WELWYN HATFIELD COUNCIL – DEVELOPMENT CONTROL
DELEGATED REPORT

APPLICATION No:	N6/2007/1290/FP
ESTATE MANAGEMENT APPLICATION No:	W6/2007/1293/EM

The application is for the erection of a replacement detached garage on the south eastern side of the property. The flat roofed garage is stepped back from the dwelling and runs along the boundary of the site with Scholars Mews. The garage is proposed to be rebuilt 0.5m longer in length and 0.3m wider than existing. The height would be increased from 2.4m to 2.95m including the parapet finish to the roof.

REAR ELEVATION

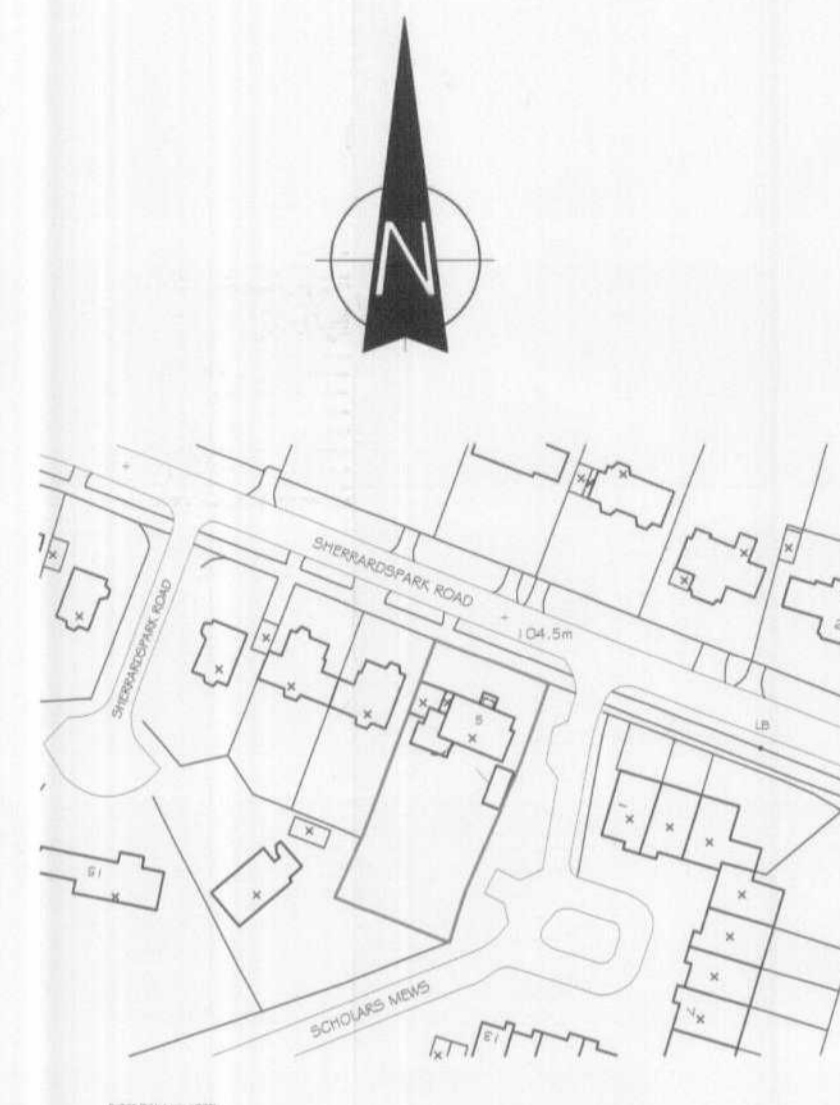
Council's arborist – considers that there is a need for a foundation design as it needs not to be below ground. They state that that the trees near to the garage are important and in need of protection and if there is not information available a condition would be appropriate.

Overall the garage would be enlarged by a small amount; the main addition noticeable in the surrounding area would be that of the increase in height by 0.55m. This would however sit below the level of the approved rear extension visible behind it. It is not considered that the rebuilt garage would be out of keeping with the character of the site or surrounding area provided that materials match existing.

3. Prior to commencement of works on site, details relating to the proposed foundations for the garage shall be submitted to and approved in writing by the Local Planning Authority. Any subsequently approved details shall be implemented in full unless otherwise agreed in writing by the Local Planning Authority.
